From: Matthew Driver [REDACTED]
Sent: 13 October 2017 14:24
To: Michael Eastham
Cc: Ian Carey
Subject: The Lillies, Yapton Road, Barnham

Please find attached the revised drawings for The Lillies, Barnham.

Plots 12-13

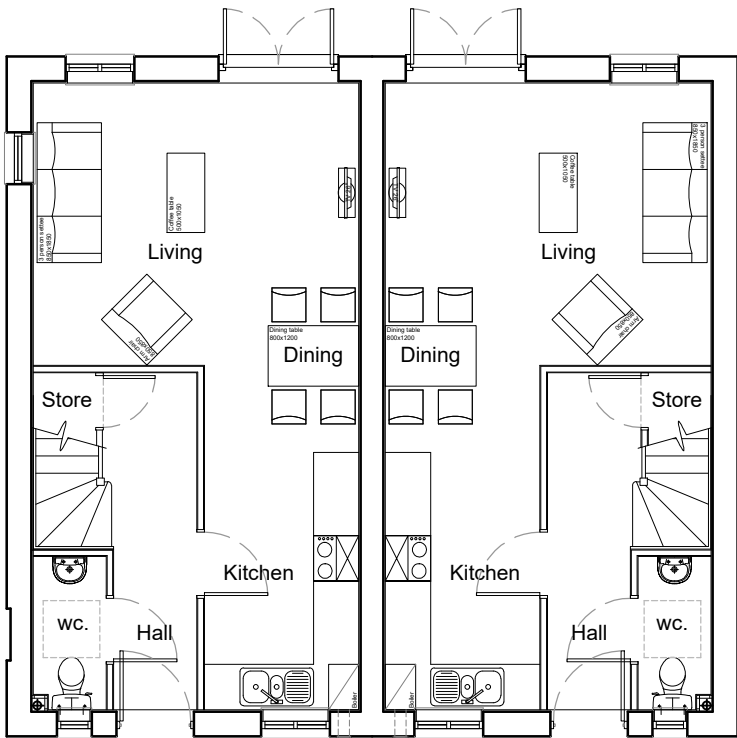
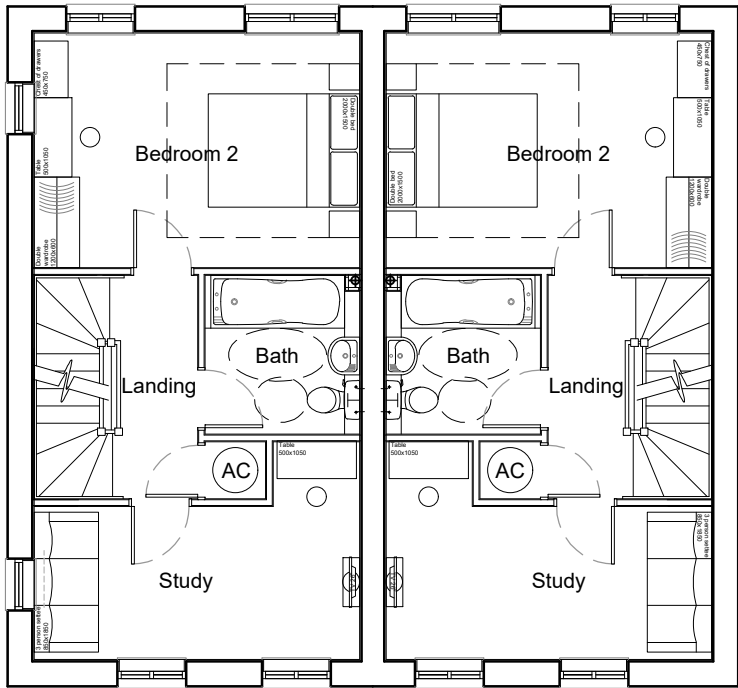
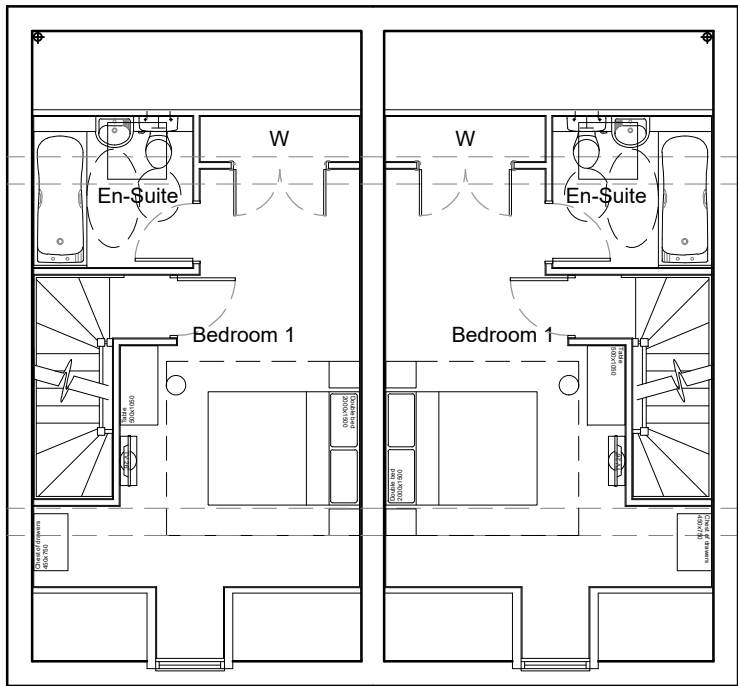
- Site layout revised to show attenuation basin, increase in hedgerow planting along site spine road, adjustment of properties to southern area of site to allow for 3m watercourse offset, Plot type revised on 12&13, link through to adjacent site allowed for.
- House type pack, general revisions to allow for stone cills to some properties, stone entrance properties to site entrance, Juliette balconies added to flats, chimneys added to HA houses, decorative brick banding added.
- Garden areas plan provided as per previous request.
